## *Rezoning Petition Review*

**To:** Charlotte Planning, Design & Development

**Rezoning Petition #:** 20-35

**Location of Property:** Approximately 49 acres located on the south side of IBM Dr, west of Neal Rd and north of University City Blvd.

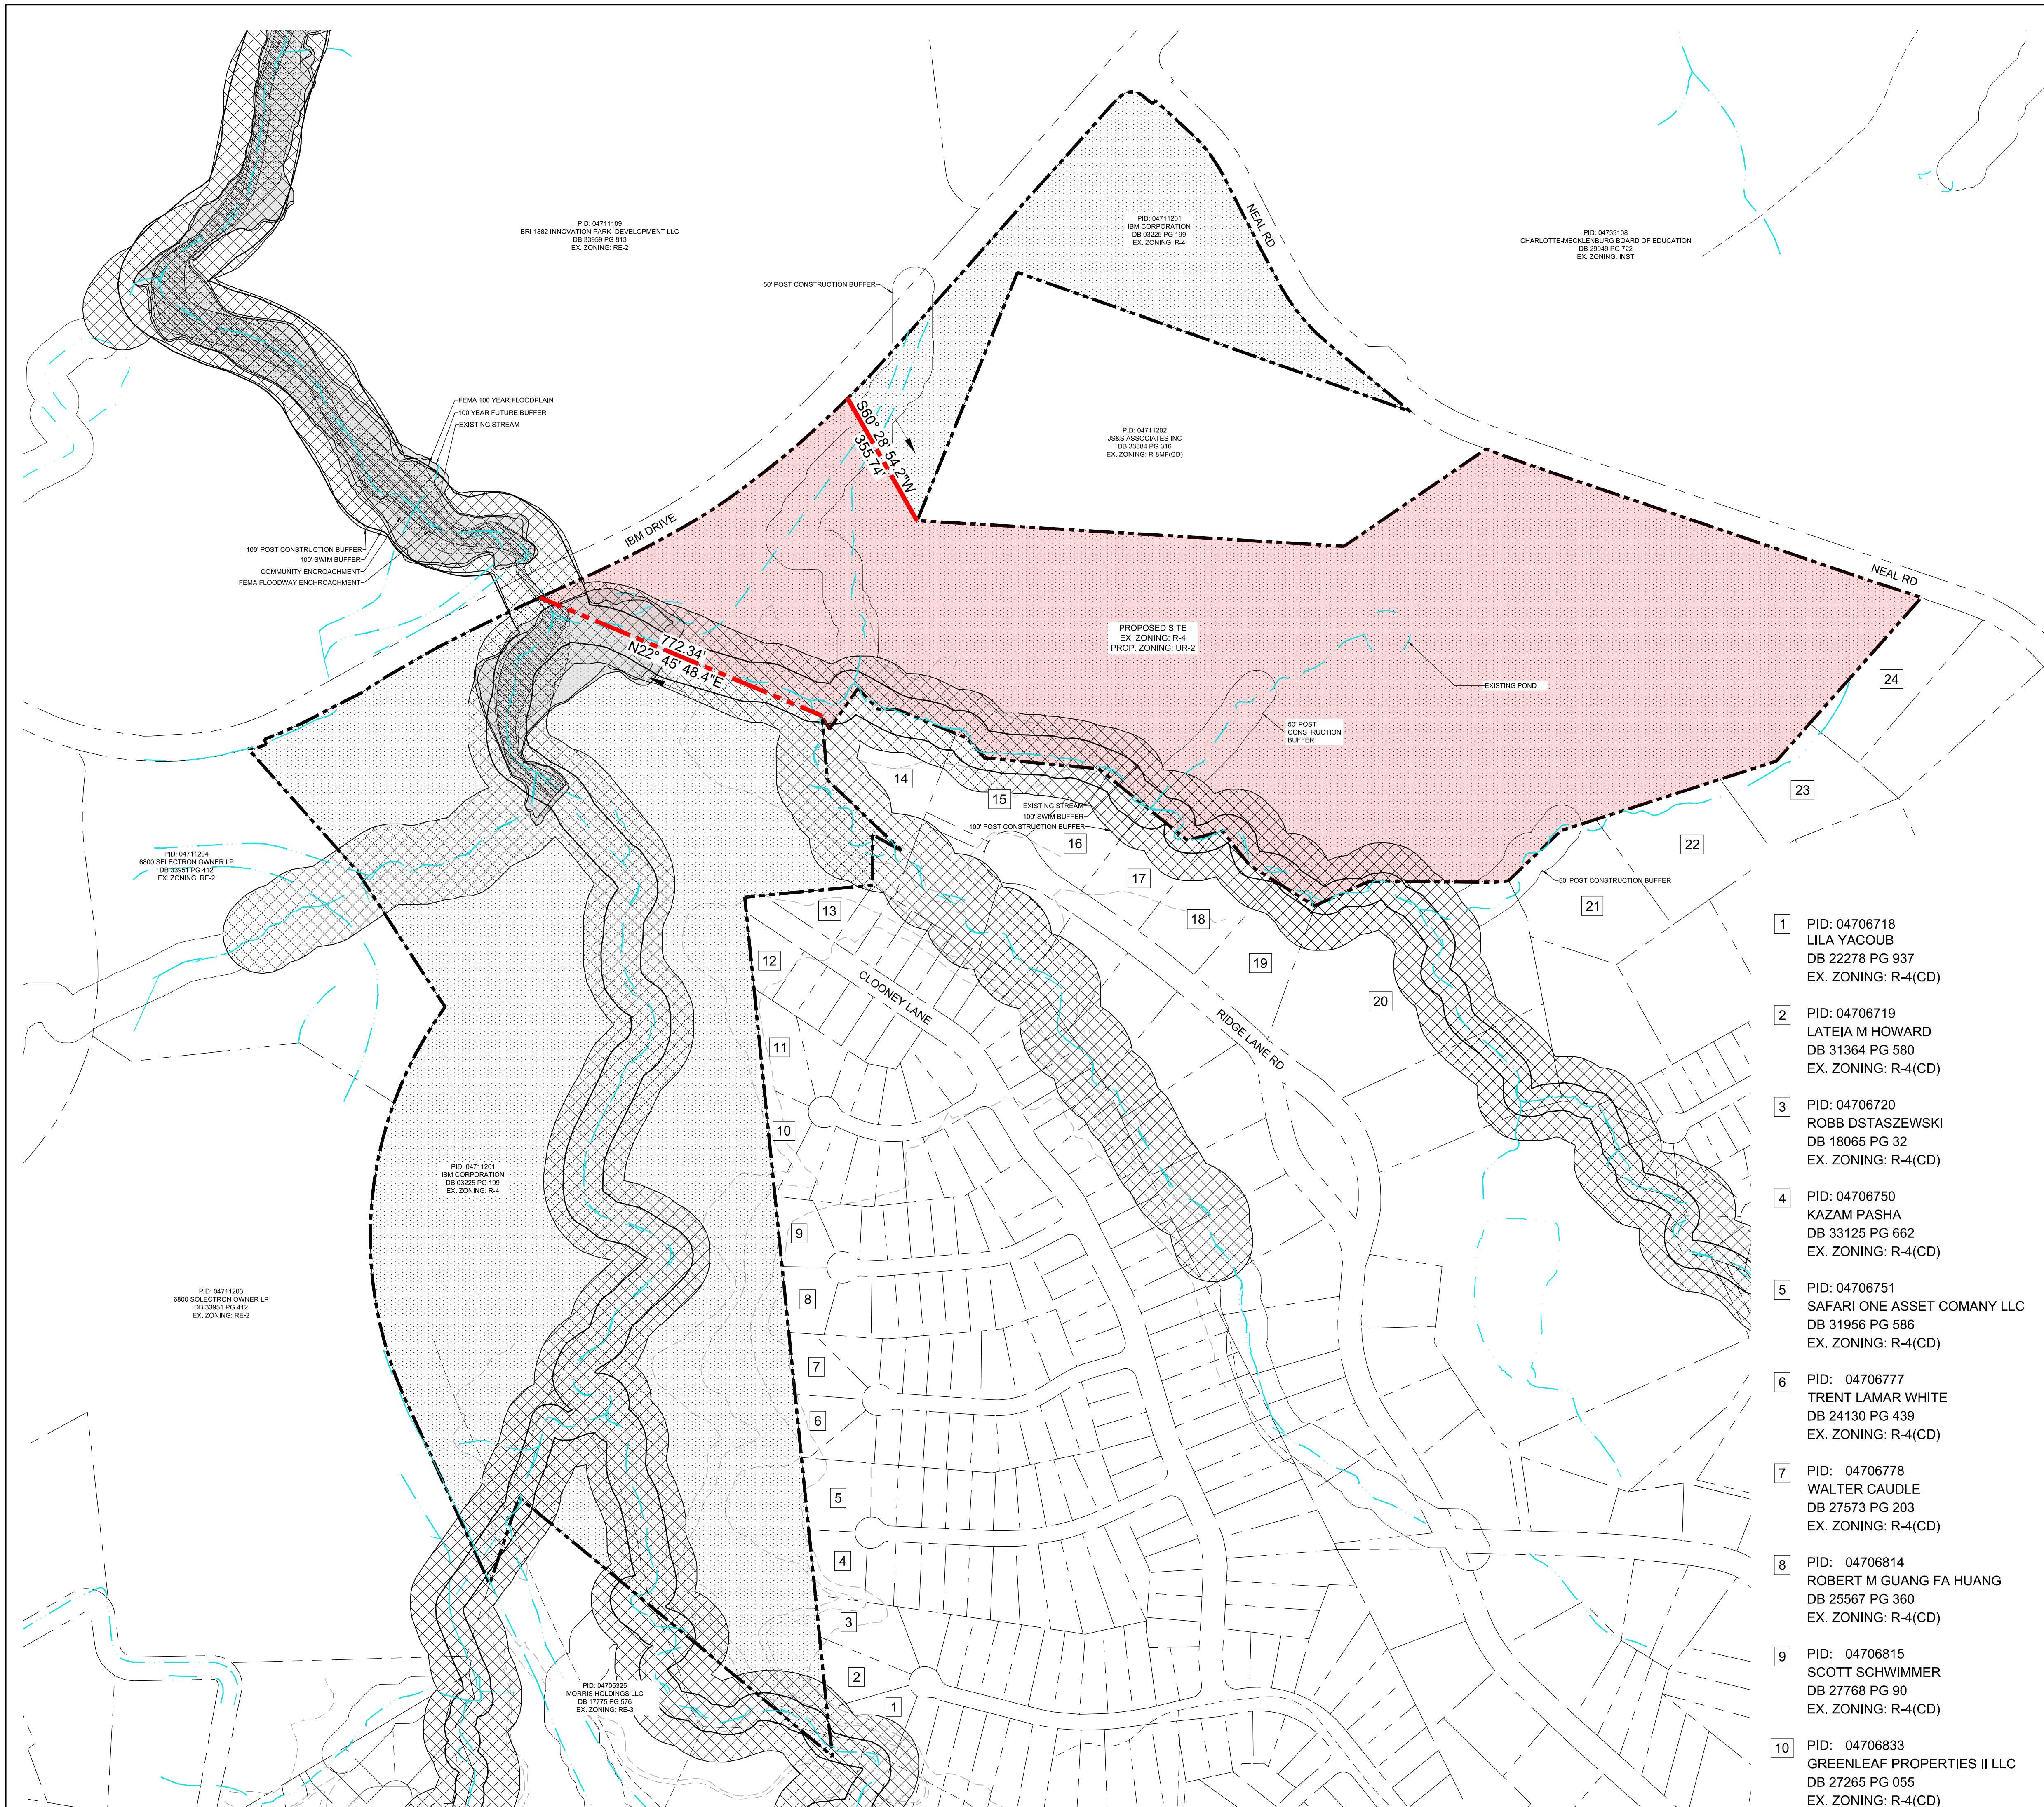
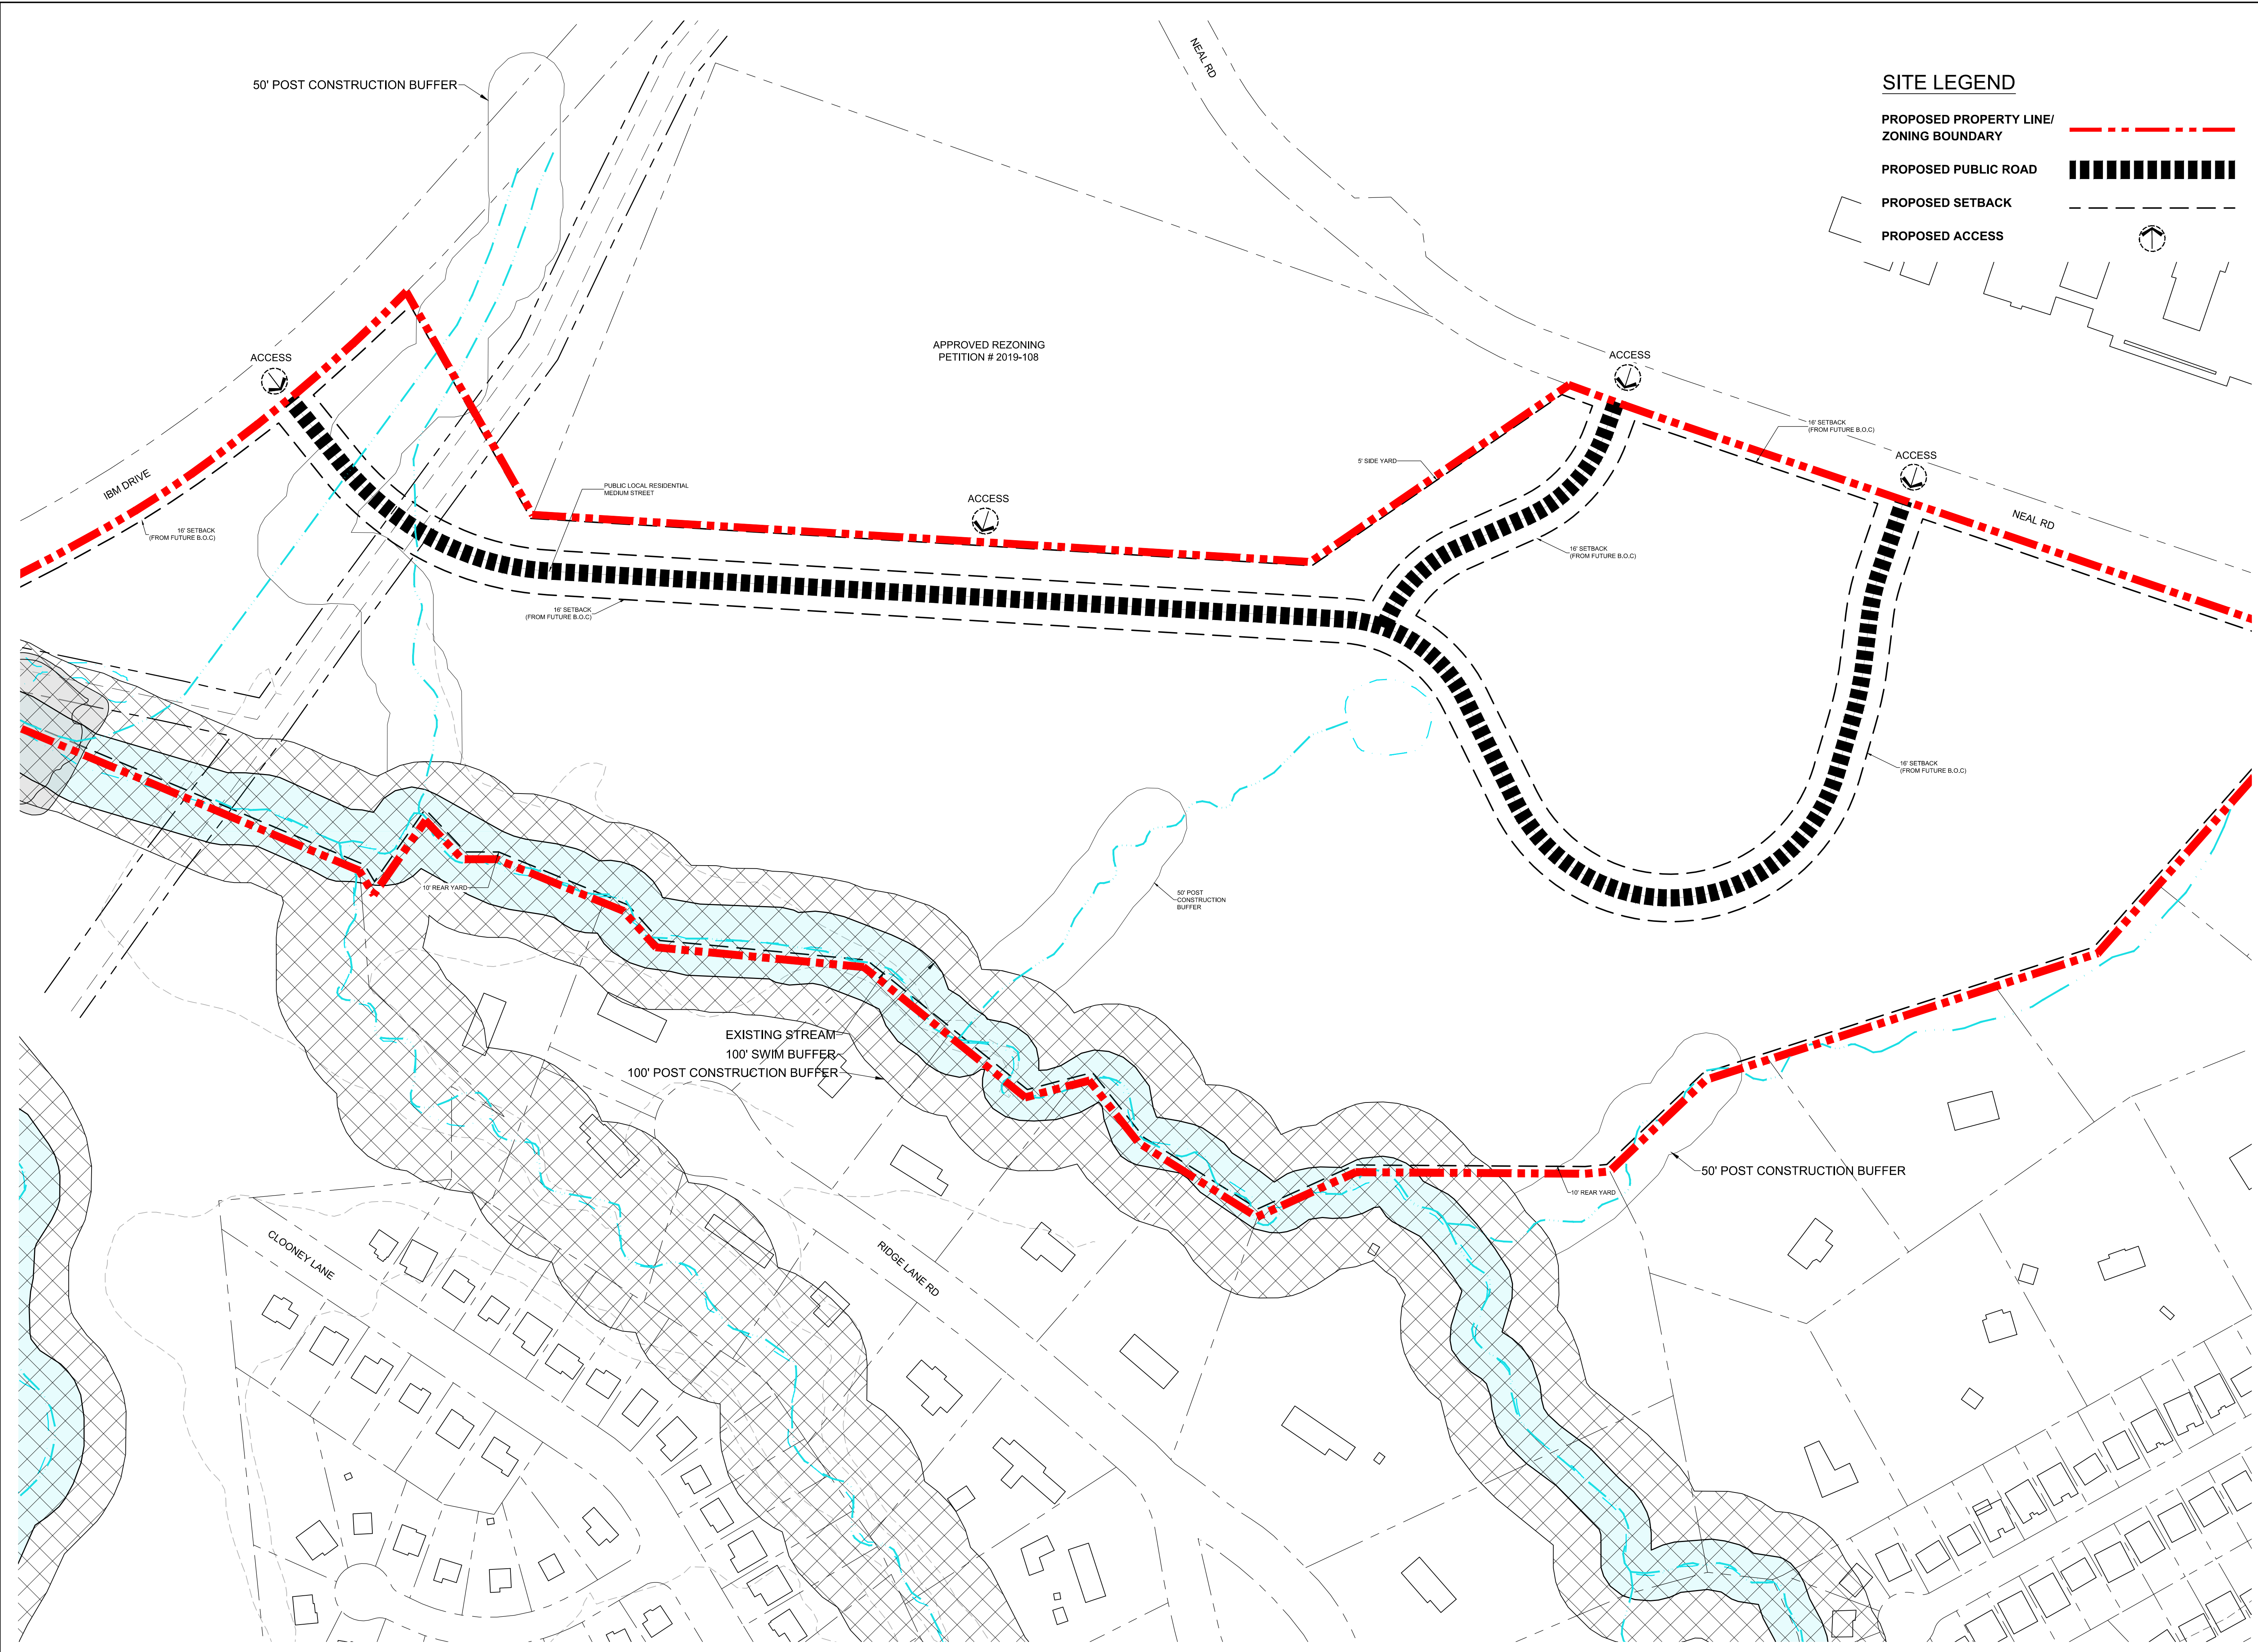
**Concerning Storm Water:** Please include the following sentence to the end of note 1 under *Environmental Features: Adjustments may be necessary in order to accommodate actual storm water treatment requirements and natural site discharge points.*

Please update 50' Post Construction Buffer and 100' Post Construction Buffer to read 50' Undisturbed Post Construction Buffer and 100' Undisturbed Post Construction Buffer. Development within any SWIM/PCSO Buffer shall be coordinated with and subject to approval by Charlotte-Mecklenburg Storm Water Services and mitigated if required by City ordinance.
